DECISION DELEGATED TO HEAD OF PLANNING
DECISION DELEGATED TO HEAD OF PLANNING
DECISION DELEGATED TO HEAD OF PLANNING

Application No:	H16-1080-23	Applicant:	Ringwood & Simpson Ltd
Proposal:	Erection of detached dwelling and garage - approved under H16-0047-23. Modification of Condition 2 to allow amendments to previously approved plans		
Location:	Rear Of 175 Hawthorn Bank Spalding		
Terminal Date:	31st January 2024

Ground Floor Plan 1:50

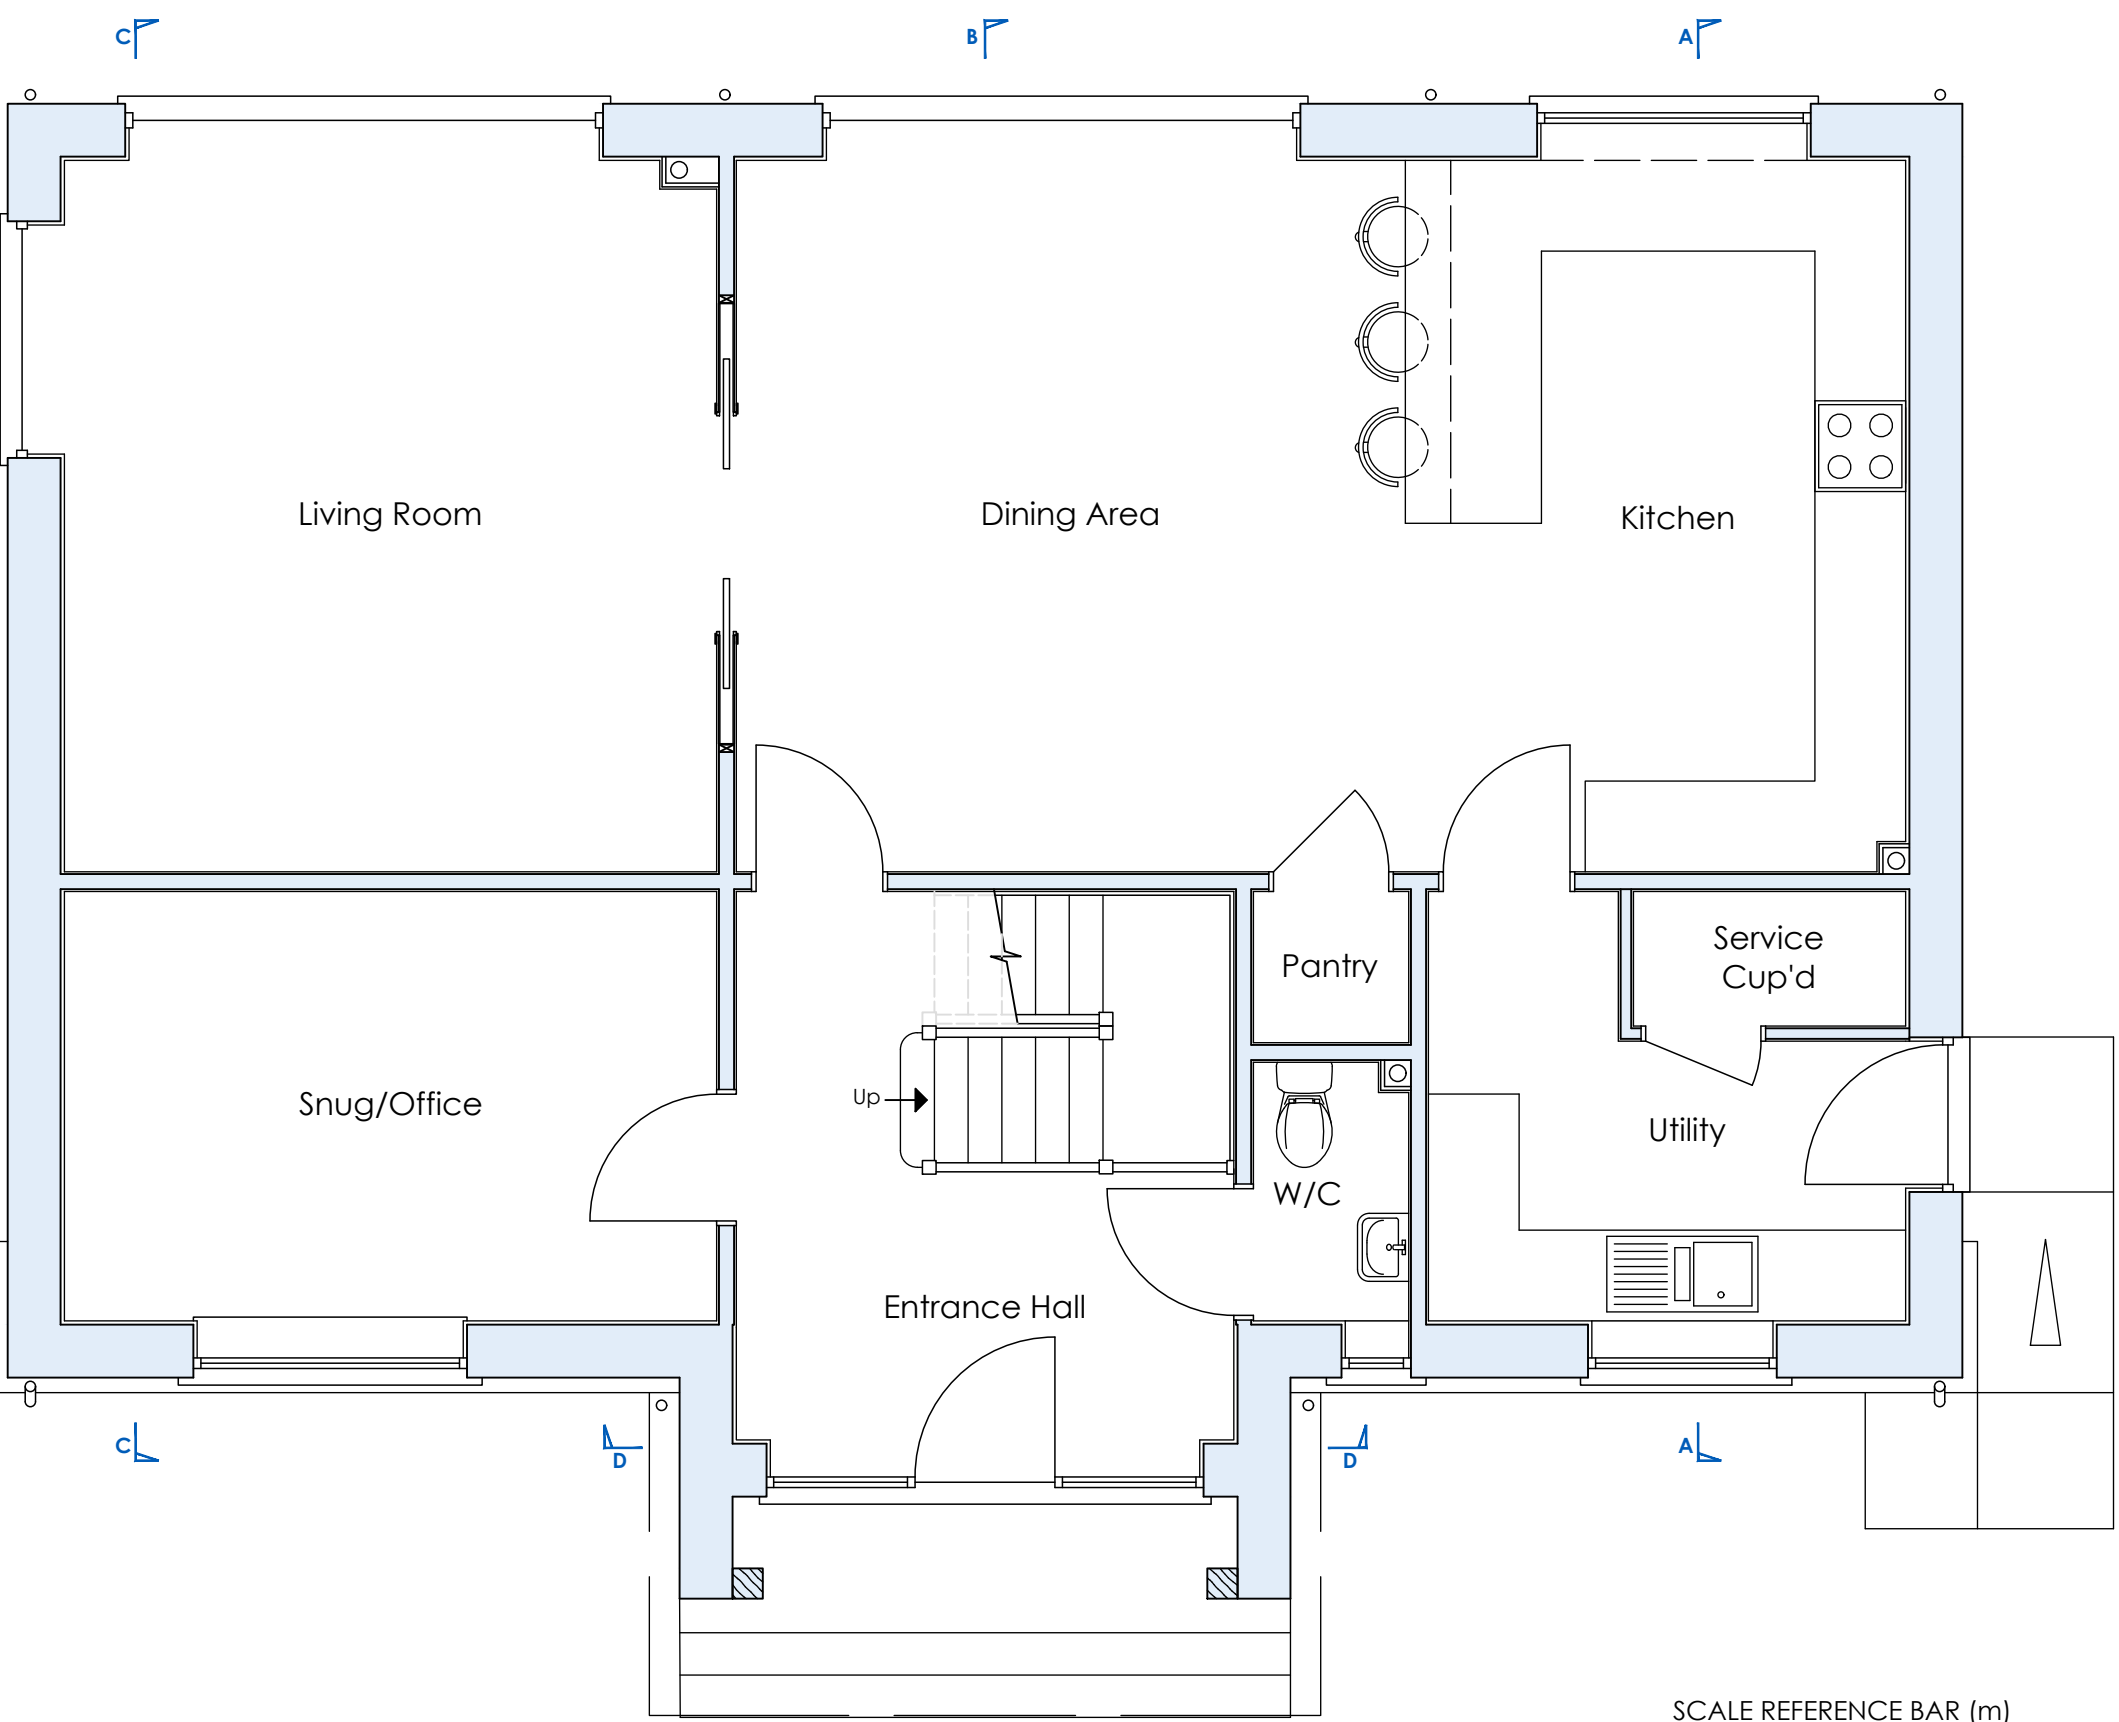
The dwelling is located on a similar footprint to what has been previously approved, the scale is also comparable, however this proposal seeks a slightly taller dwelling, though this is slightly mitigated by the ability to built to finished floor levels of 3.3m AOD (a topography plans now shows the existing site levels are set at circa 3.00m AOD, lower than previously assumed within the FRA).

Architecturally the dwelling now exudes a greater symmetry with a central two storey entrance porch which contains an internal 'galley' balcony area at first floor. 1st floor openings straddle the eaves creating catslide style dormers (this keeps the overall height down), two of which are located on the principal elevation and 4 on the rear elevation. Two sets of bi-folding doors are located to the rear and exit onto a raised area which steps down into the garden. There are also steps leading up to the main central entrance on the front.

The proposed changes to the dwelling itself are considered acceptable, the palate of materials and the central porch would provide a dwelling of high merit. The boundary treatments surrounding the rear amenity, which are proposed to be at 2.1m are considered to have a mild character effect, especially upon adjoining neighbours visual amenity. This impact however is localised and the separation distance from the neighbouring dwellings to these boundaries mitigate unacceptable harm. It should be noted that 2m boundary treatments are available to future residents through applying PD rights.

The proposed dwelling which slightly taller would not result in an unacceptable impact upon neighboring amenity through overshadowing/overbearing when considering what is already approved on site. The location of openings are commensurate with those previously approved. The dwelling however has set finished floor levels at 300mm above existing ground levels (as required by the FRA), following the site being surveyed these levels are 3.3mAOD. It is considered that this is acceptable. The proposed fencing to the rear boundary is 2.1m in height and this is also acceptable. The impact from the car port is considered acceptable, commensurate with what is allowed under previous permissions.

Drawing No.
2474-12A

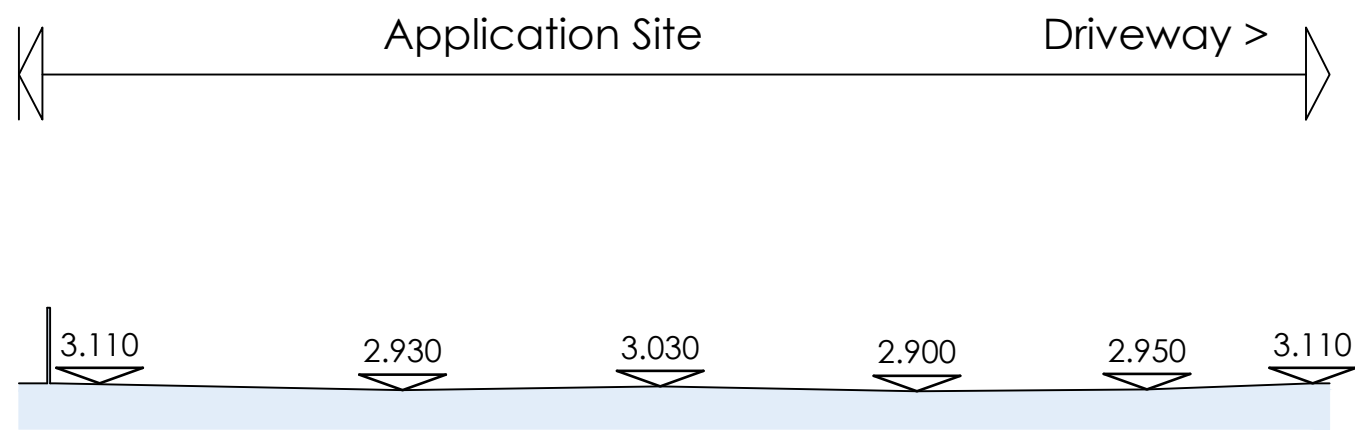
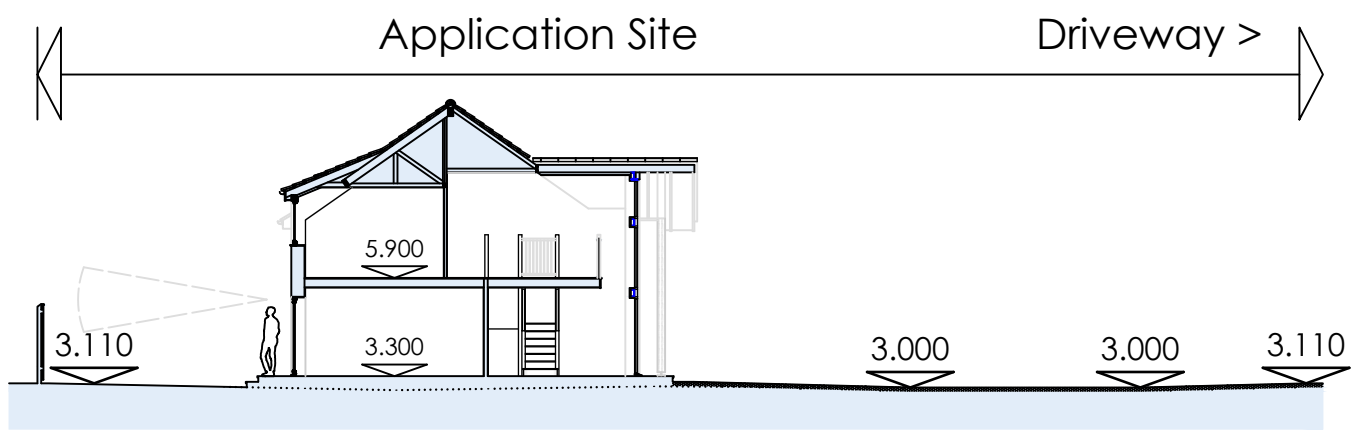
This application seeks to amend the design of the dwelling previously approved on the plot. Whilst the footprint and location of the proposed dwelling remain similar there are changes architectural features. The applicant also includes information on finished floor levels which are to be set at 3.3m AOD. Information has also been provided as regards the protection of trees during construction. The applicant has also provided a landscaping plan detailing that a proposed 2.1m close boarded

timber fence will be erect around the perimeter of the rear amenity area.

**Drawing No.** 2474-13

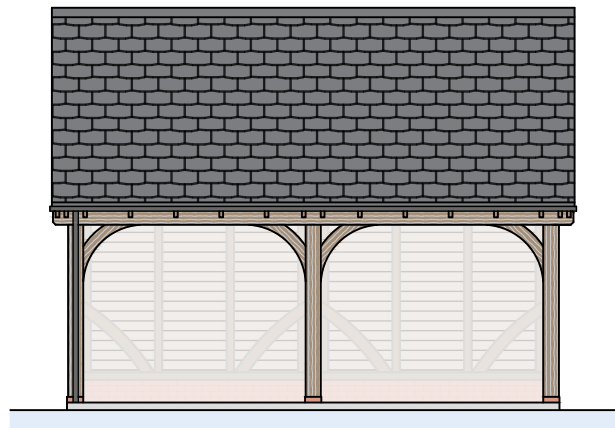
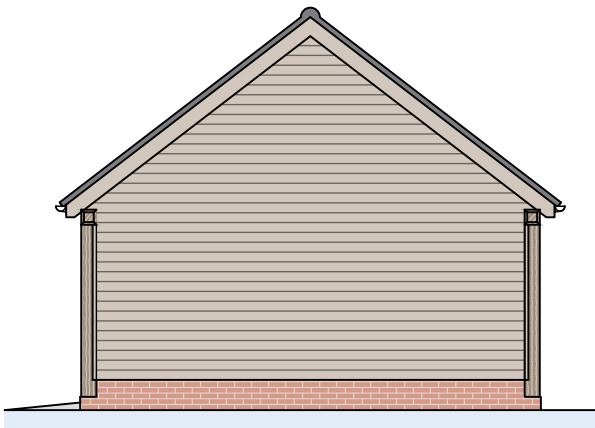
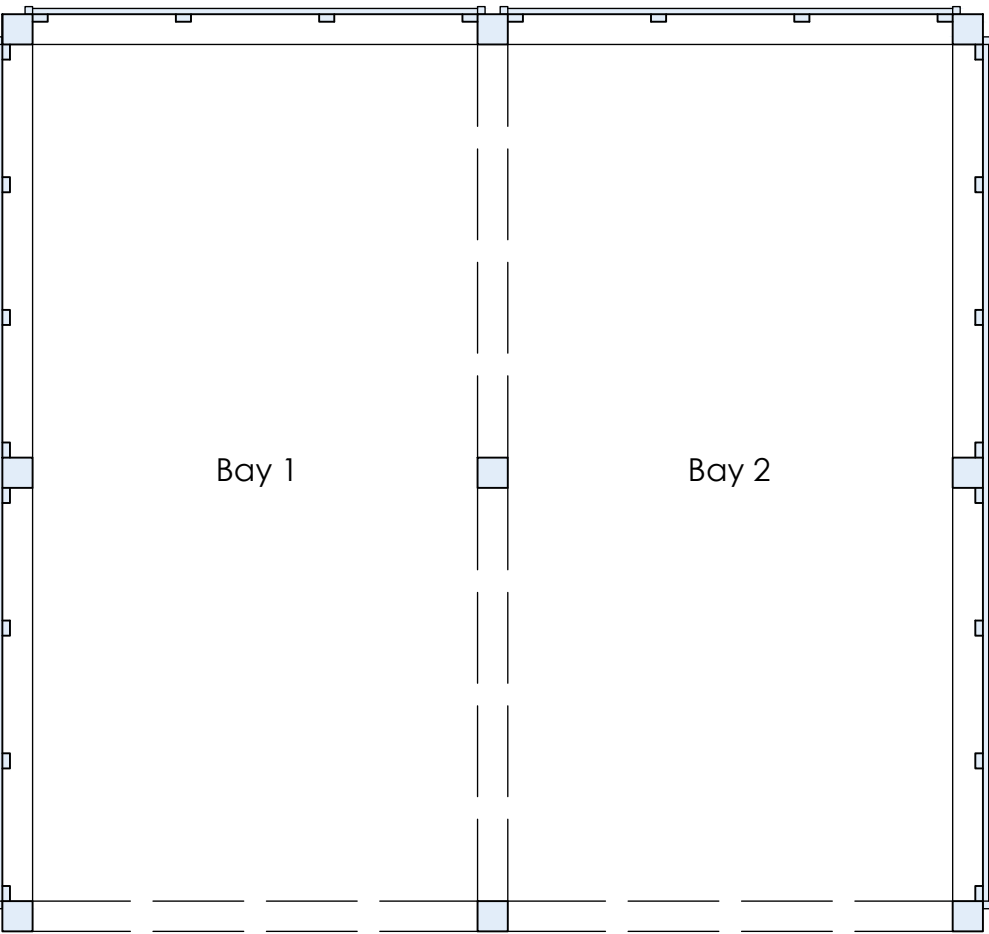
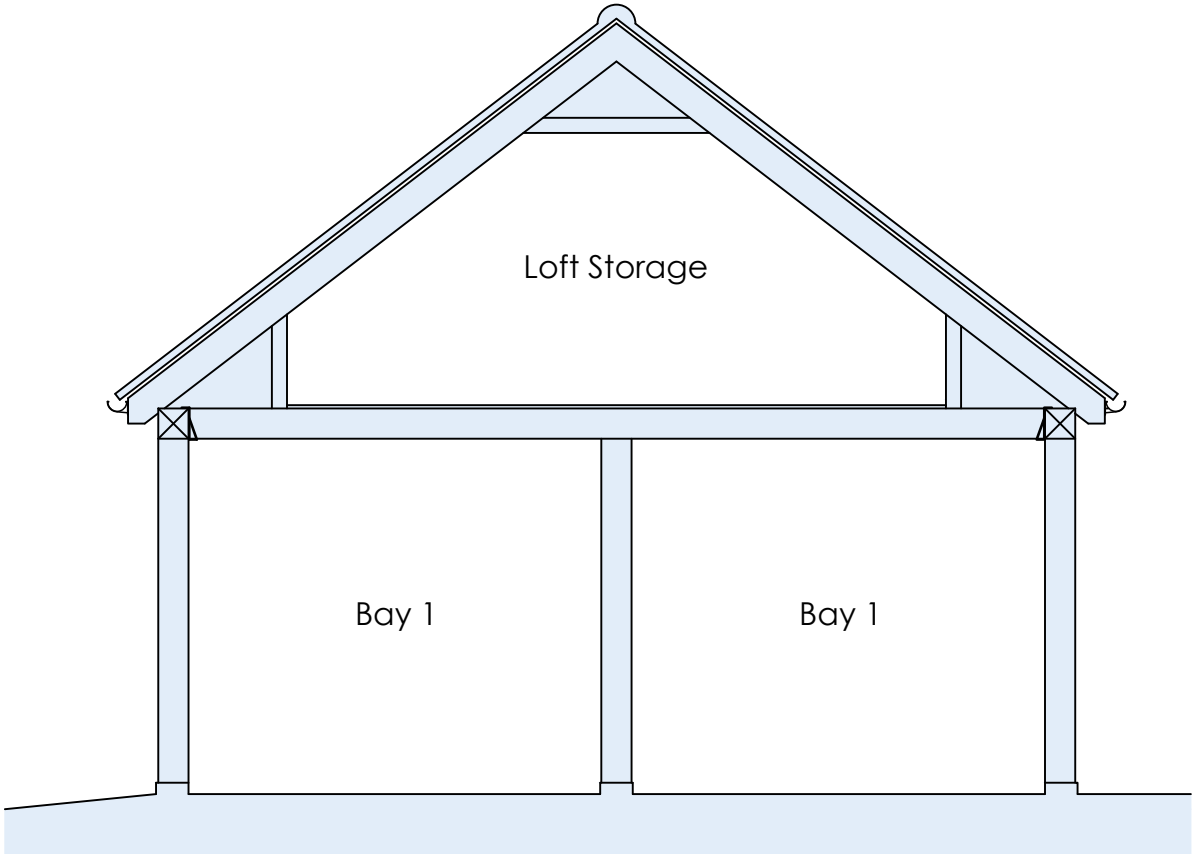
The dwelling is set back and would not have a great effect upon the street scene, but would be visible. It is considered that the dwelling, given the scale previously approved would not result in an unacceptable impact upon the areas character and appearance. The impact from the car port is considered acceptable, designed to a high level, but largely unseen from Hawthorn Bank..
